Objection to Planning Application: 2025/93355

Address of Site: Land off Woodward Court/Hepworth Lane

EXISTING 30MPH SPEED LIMIT ON HEPWORTH LANE BUT SEE NOTE 2 FOR ACTUAL SPEEDS

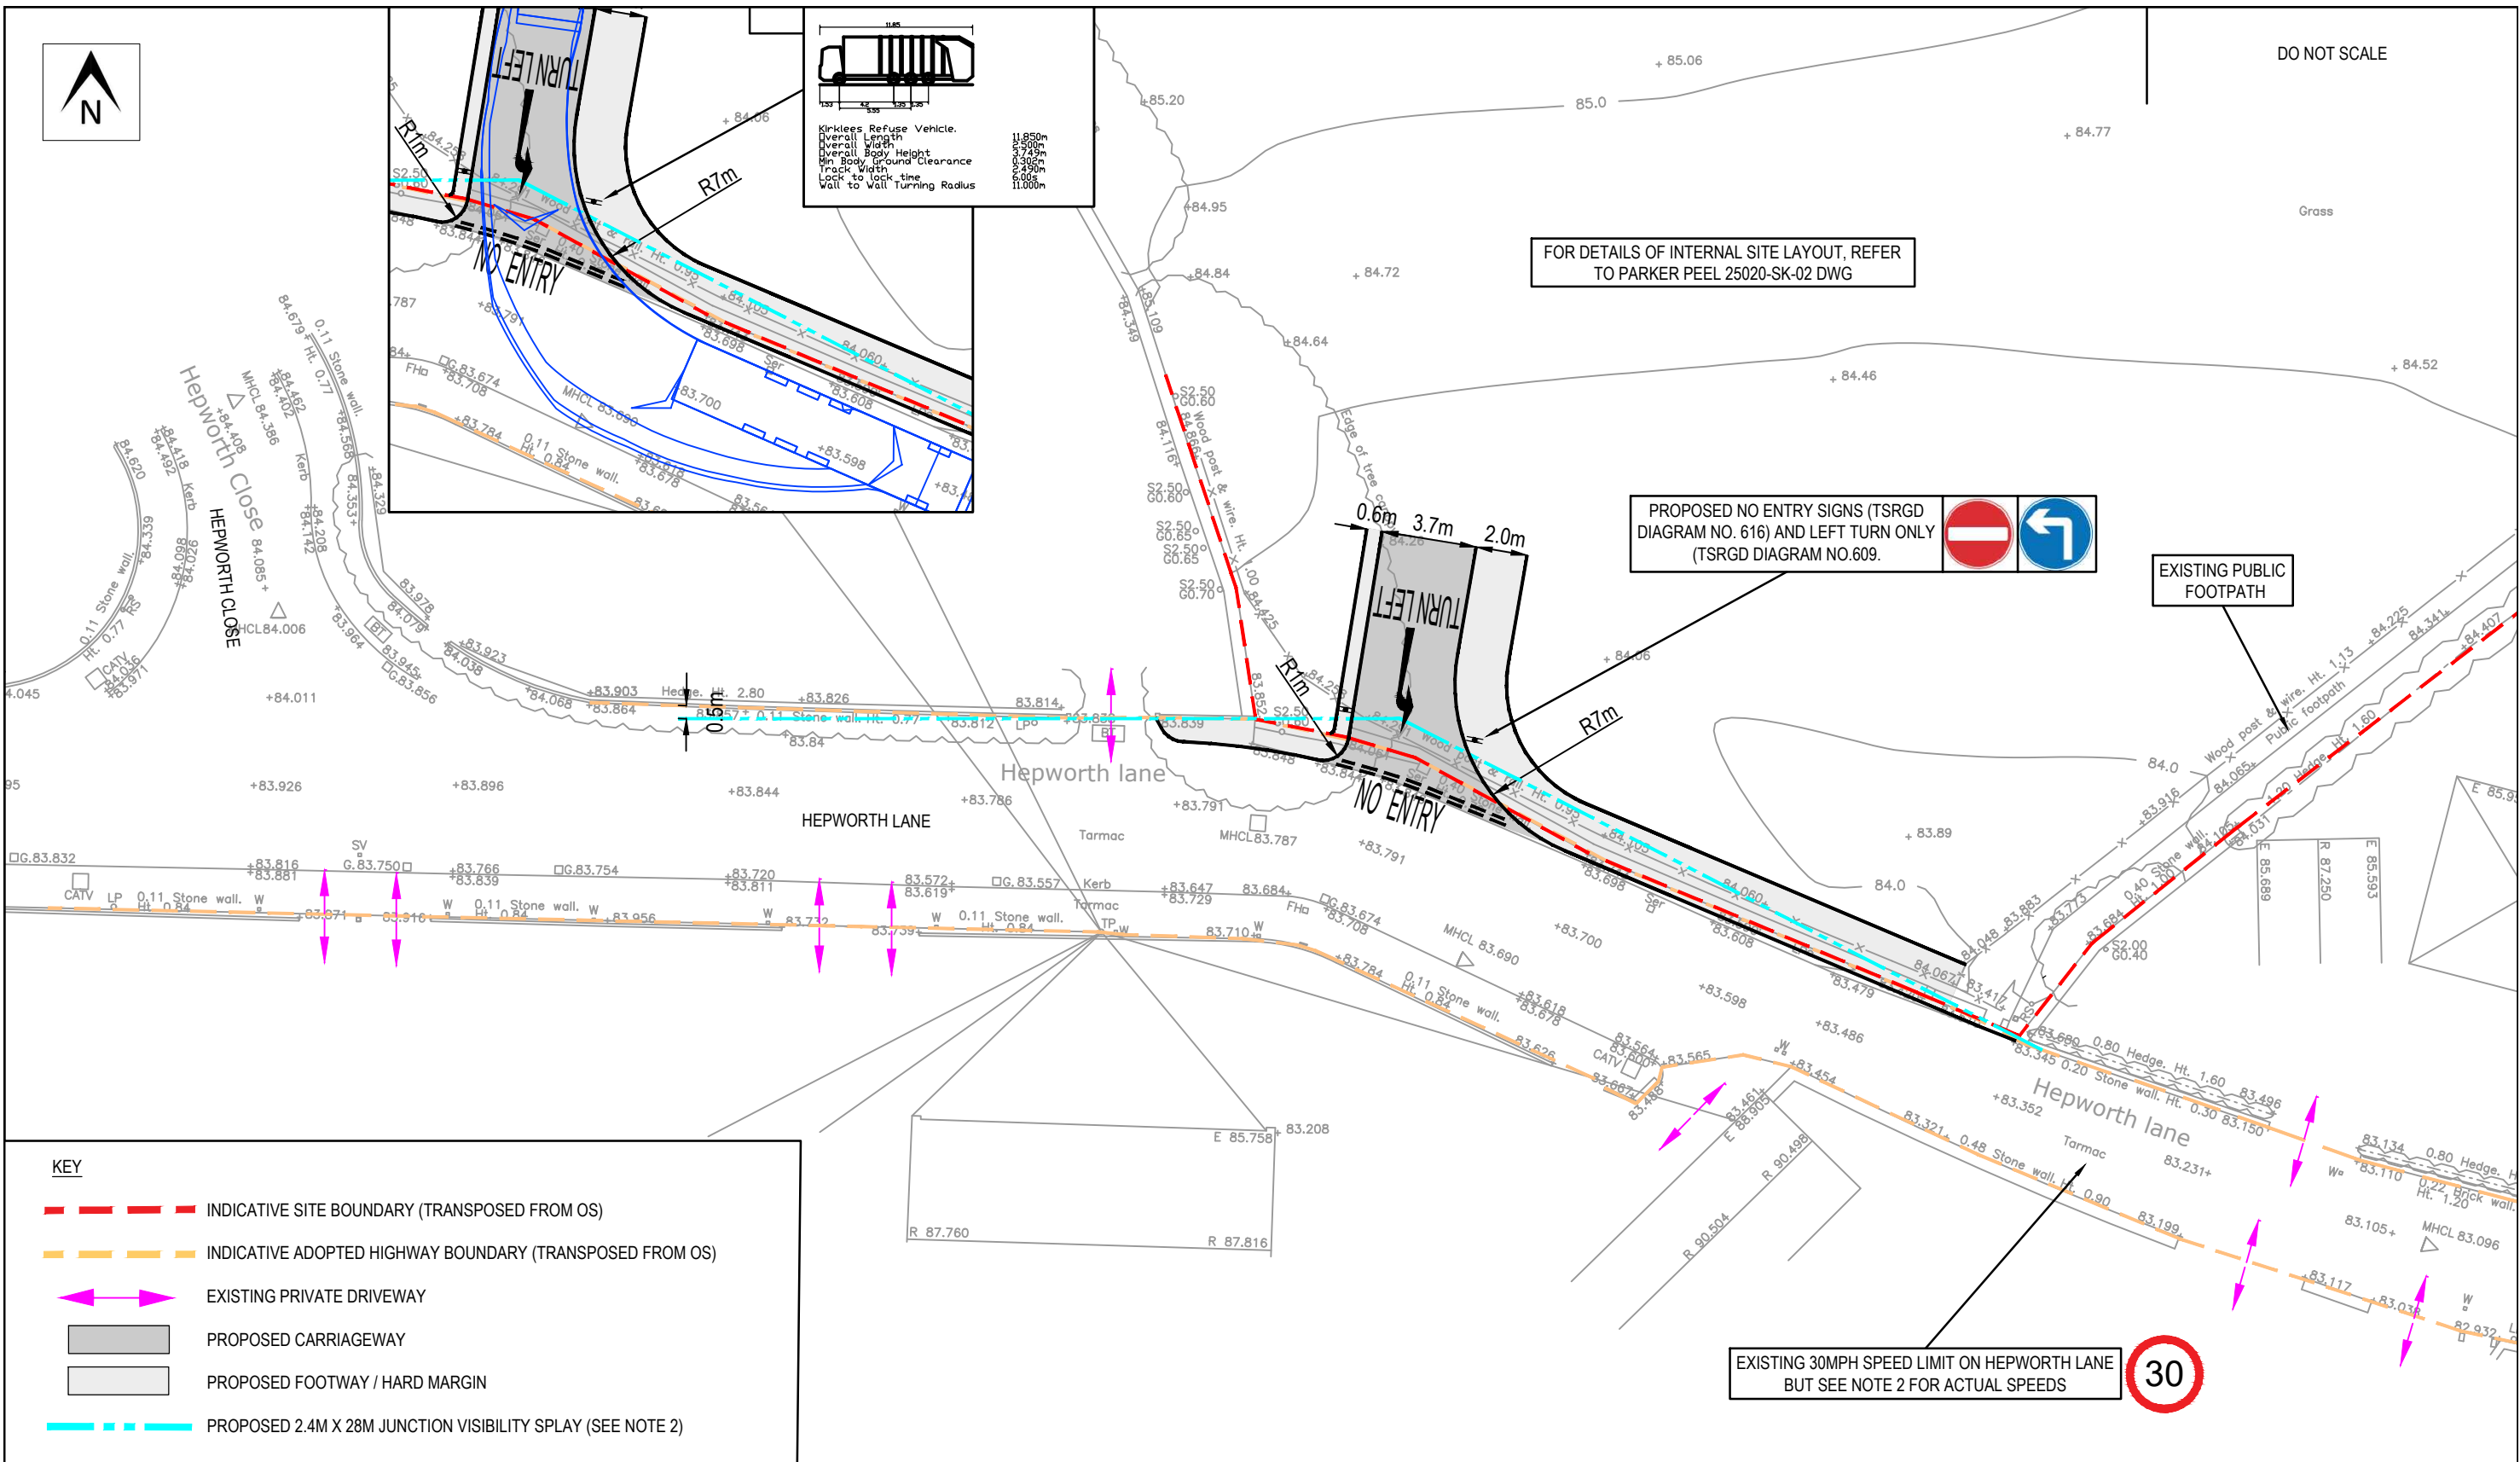
Hepworth Lane is already a constrained route that struggles to accommodate current traffic volumes. My primary objection relates to the lack of adequate pedestrian infrastructure. There are significant stretches of this lane with **no designated pavements**, forcing pedestrians to walk directly in the carriageway.

, I remain active and value my independence; however, navigating Hepworth Lane is becoming increasingly hazardous. An additional exit from the Bellway development will inevitably lead to an increase in vehicle movements. This intensification of traffic, without a corresponding improvement in pedestrian safety or the provision of footways, creates a severe risk of conflict between vehicles and vulnerable road users.

In summary the proposed additional exit will exacerbate an already dangerous traffic situation on a 'lane' unfit for higher volumes, particularly for elderly residents like myself.
